Response to Planning Points received 27 Jul 2021

2 Coplaw Street Glasgow G42 7JE, GCC Application Ref: 21/02249/FUL

DRAWING NUMBER:-
LS21-152-001

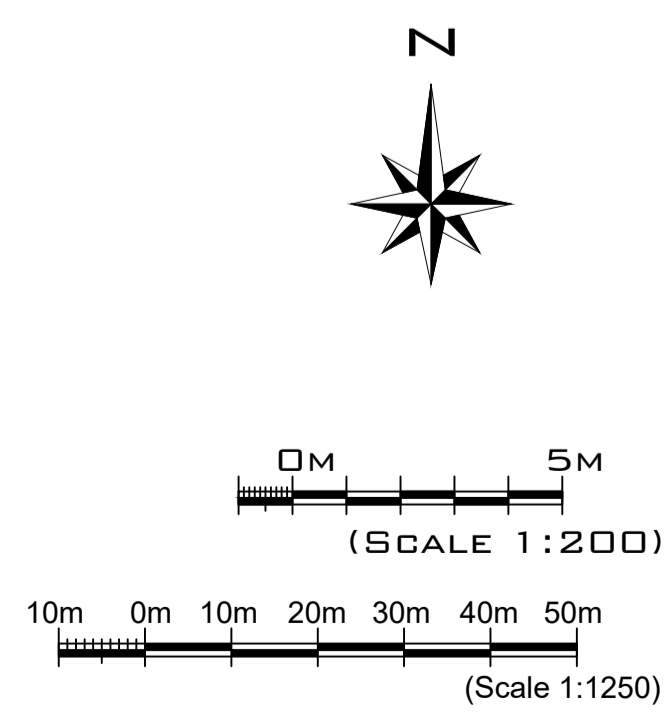
LOCATION and BLOCK PLAN (drg. no. LS21-152-001) : please revise the block plan

drawing to include a note of the existing site perimeter treatment and also indicate the direction of north to the plan document;

- [All Revised and uploaded.](#)
